Eastergate Parish Council
Mr GR Sleet
12 The Cedars
Barnham
Bognor Regis
PO22 0EZ

9th October 2012

Laying of permeable hardstanding, A/C unit/enclosure, handrail and external lighting
17 Elm Grove South Barnham

TITLE SITE PLAN

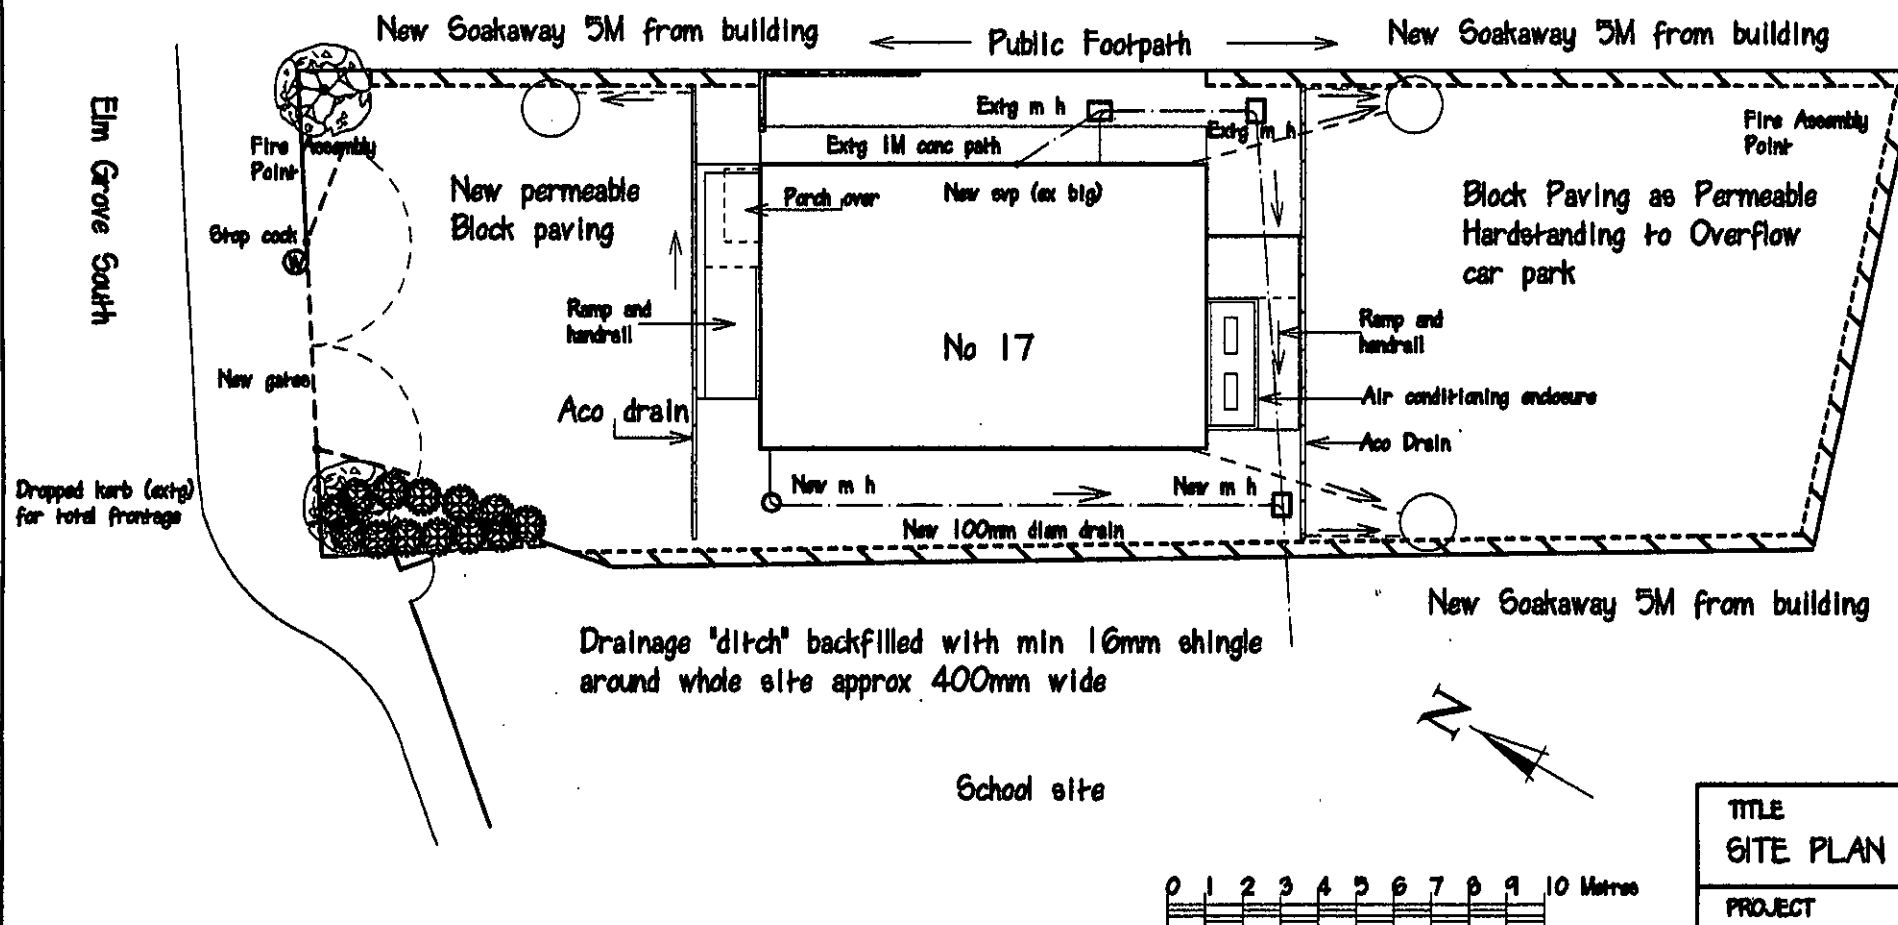
The council objects on the ground that the proposal will cause unneighbourly noise through parking and general use of the property for non residential activities. The parking appears inadequate for the proposed use and parking is likely to occur "on road" in a dangerous location near to St. Philip Howard School and a sharp bend. The WSCC travel Plan requires a larger kerb near the school for safety, and there is no application for a "dropped kerb" apparent from the papers.
